# EAST PRESTON PARISH COUNCIL

27<sup>th</sup> April 2020

**Re: EP/37/20/HH, 56 Angmering Lane**

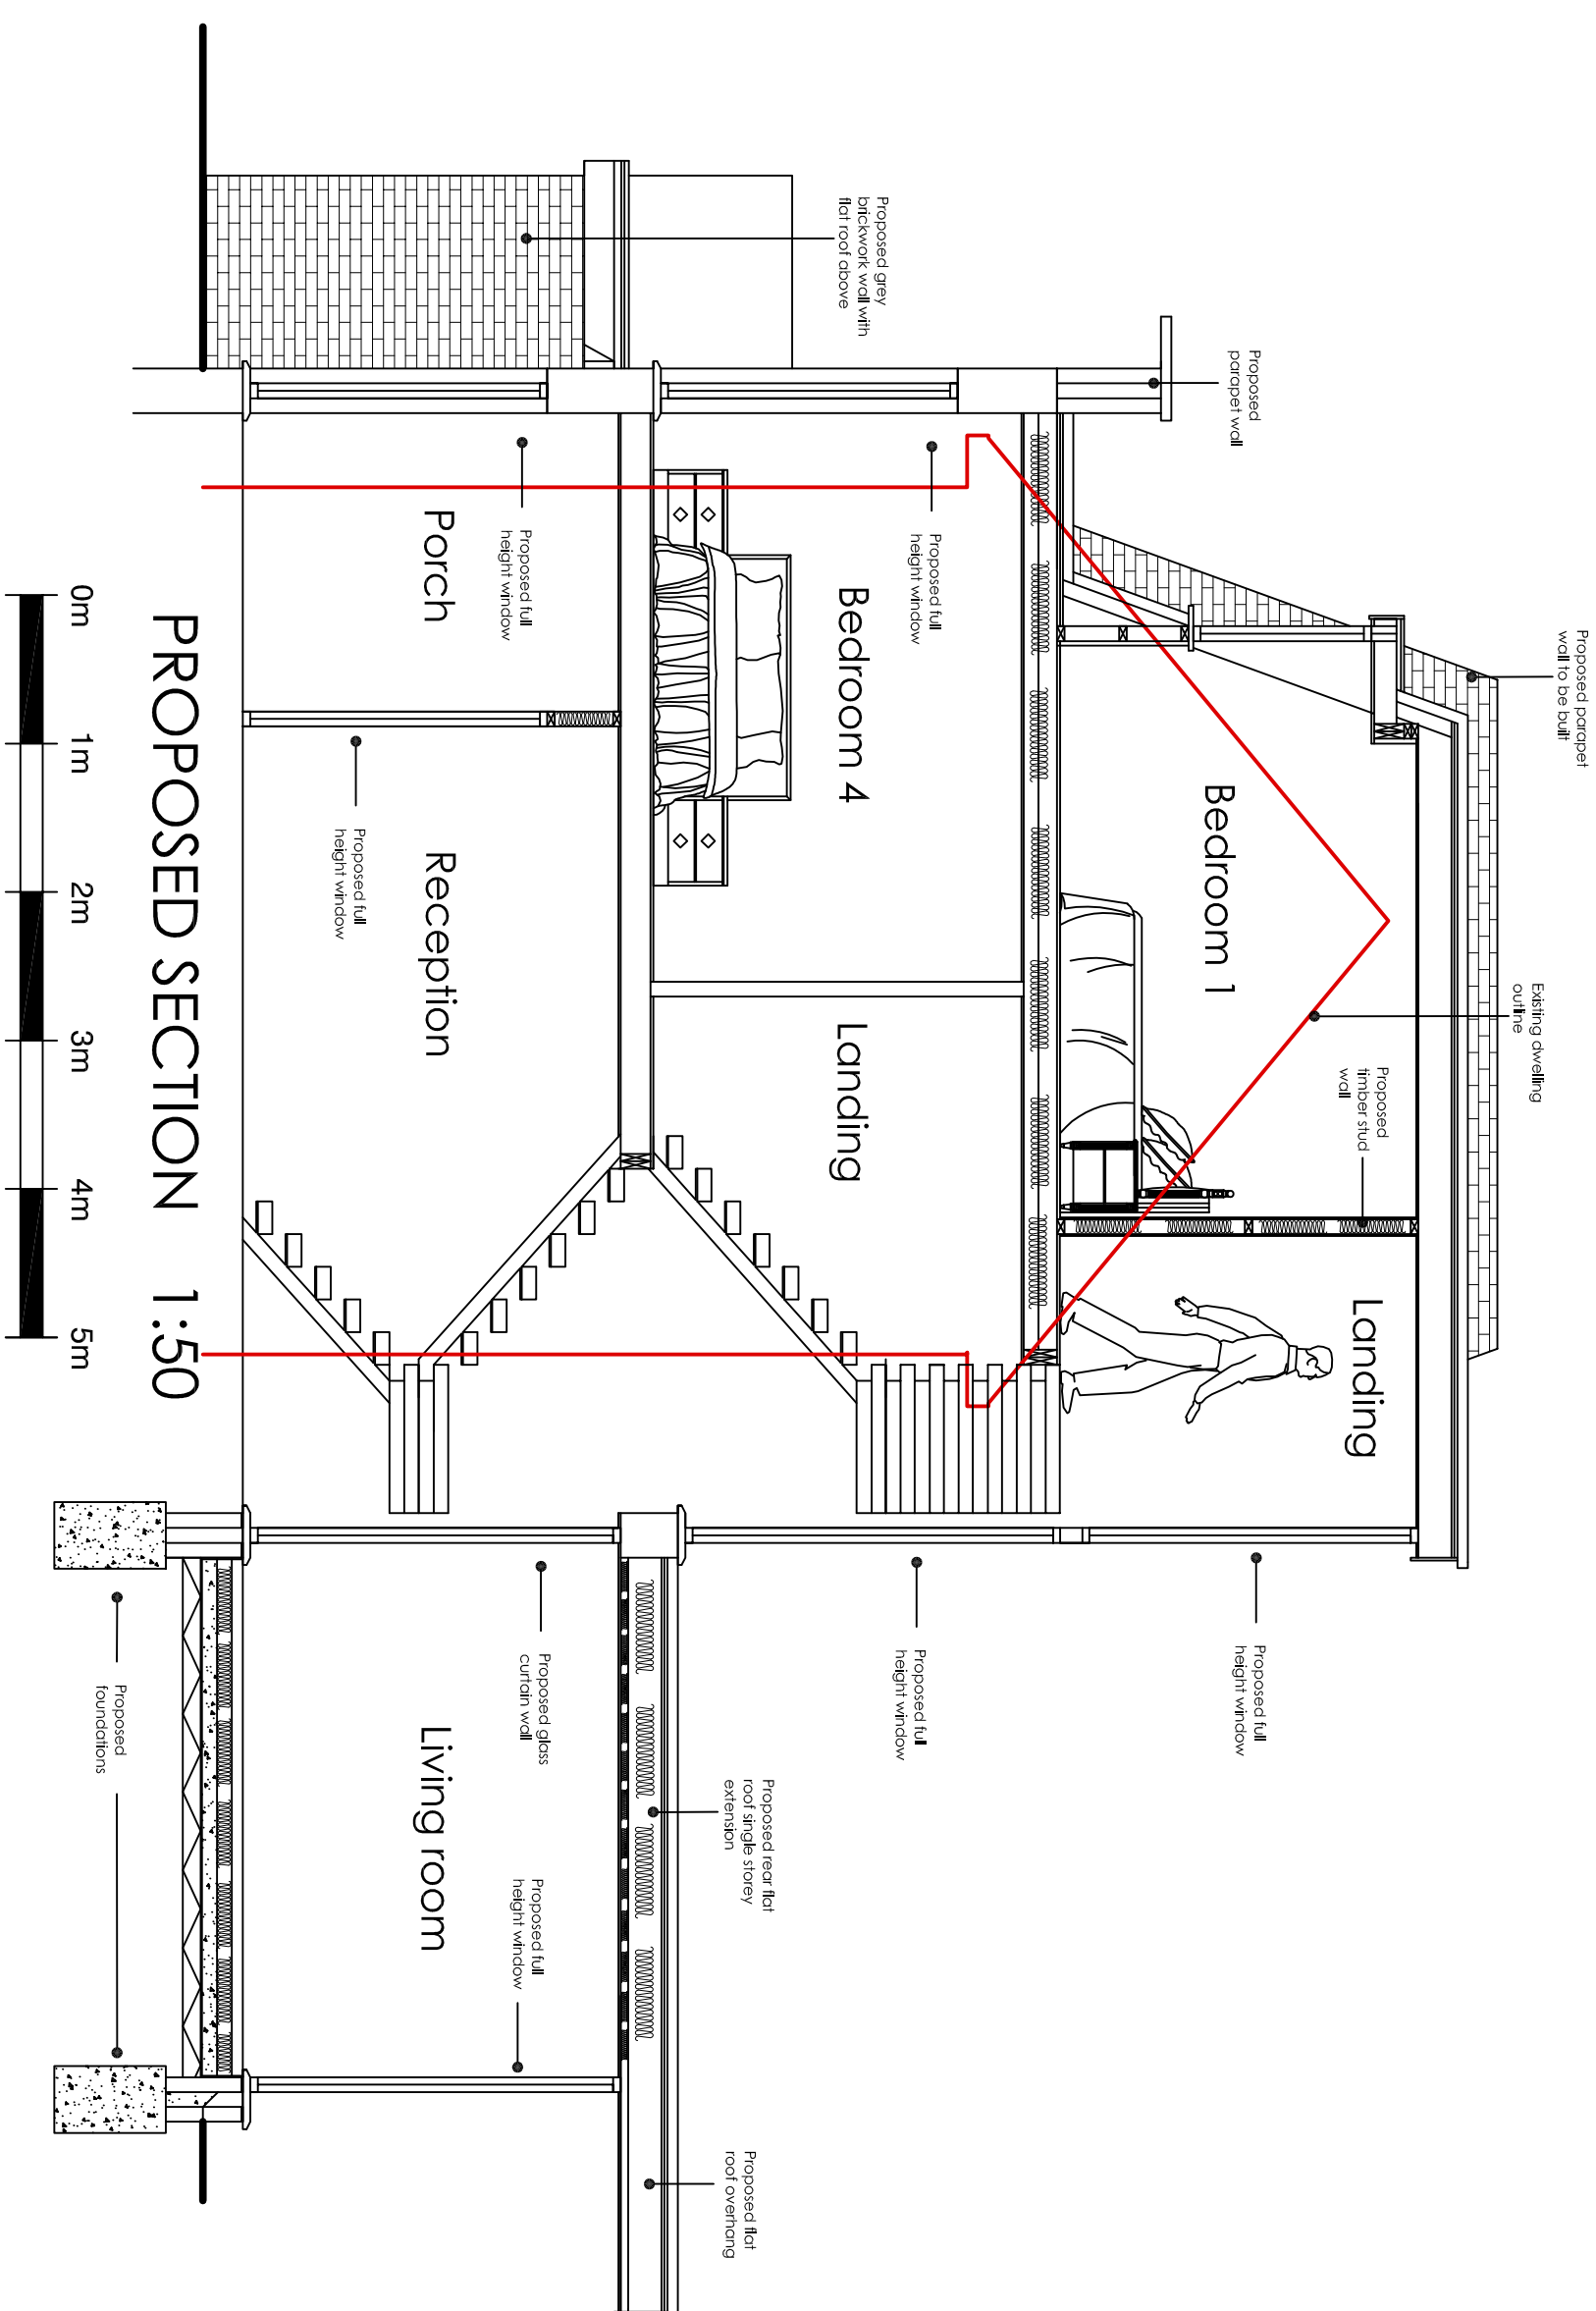
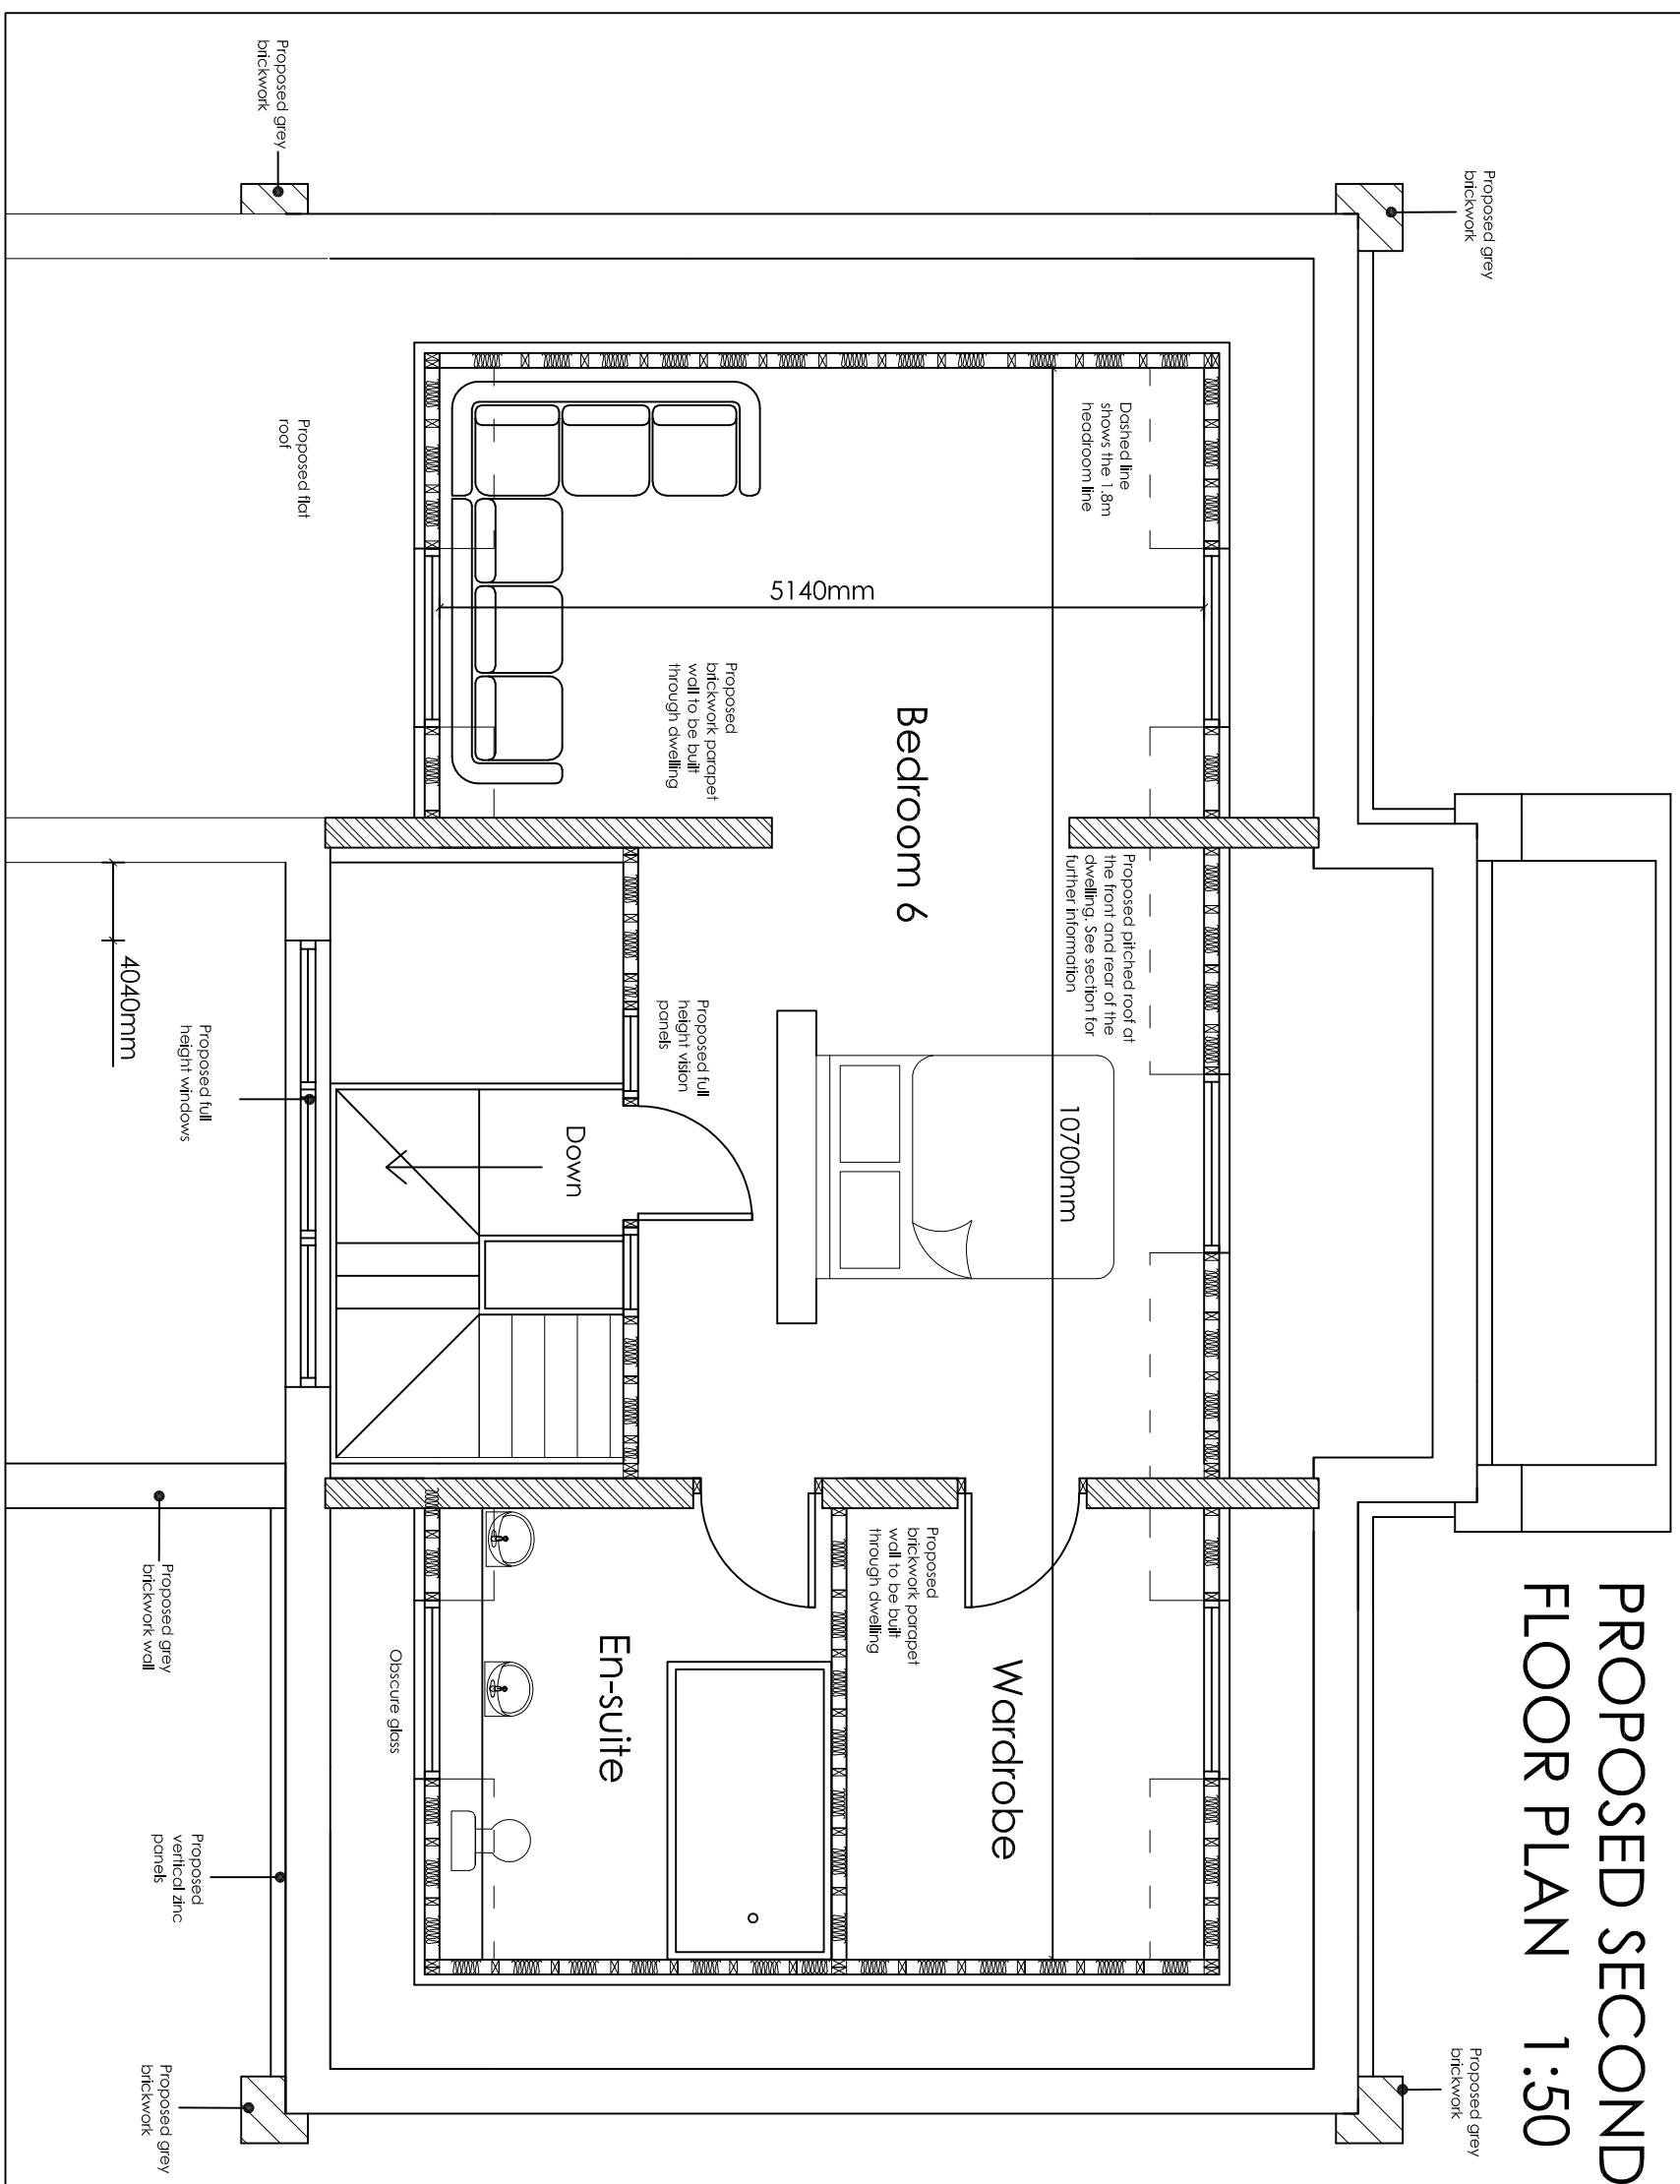
The proposed development is considered to have a significantly harmful impact upon the character of the street scene, and the wider locality, due to its modern appearance, and significant scale. As such, the proposed development conflicts with Policies D DM1 and D DM4 of the Arun Local Plan, and Policies 1 and 2 of the East Preston Neighbourhood Development Plan.

The proposal also conflicts with Policy D DM4 as the does not sympathetically relate to nor is it visually integrated with the existing building in massing, design, form scale and materials. Equally, the extension could not be considered visually subservient to the main building.

The proposed materials are contrary to Paragraph 4.12 which states, "The materials used in new or altered buildings should harmonise in both colour and texture with the materials used in adjoining buildings." Zinc cladding is proposed for the top storey. This council does not believe any other properties on this estate have zinc cladding. Therefore any use of such cladding will leave this property out of keeping with the locality. The same can be said for the proposed use of grey brickwork.

Paragraph 4.14 of the East Preston Neighbourhood Plan states "New or altered buildings that exceed two storeys in height will rarely be acceptable." The proposed redevelopment includes an increase in the height of the property which may appear minimal, but the proposed design of the top storey will result in a property looking much higher without the softening effect of a pitched roof. The resulting property will be out of keeping with the street scene and unneighbourly. The addition of windows in the proposed second storey will directly and unacceptably remove the existing privacy of neighbouring properties. Obscured glazing is proposed for one set of windows on the second floor eastern elevation, presumably to reduce people seeing in, which suggests other windows will be able to see into other properties.

The flat-roofed design of the property is out of character with the rest of the Willowhayne private estate. The existing property is quite visible when approached down Angmering Lane, although it is screened from view directly in front of the property. Because of the increase in mass, the proposed property would have a much greater presence when viewed from further up Angmering Lane, only serving to highlight how out of character the proposed property would be. There is no indication given as to whether the existing screening at the front of the property is to be retained. This could be seen as contrary to Paragraphs 127 and 130 of the National Planning Policy Framework.

The proposed garage is in front of the existing building and is therefore a negative impact upon the spatial character of the area.
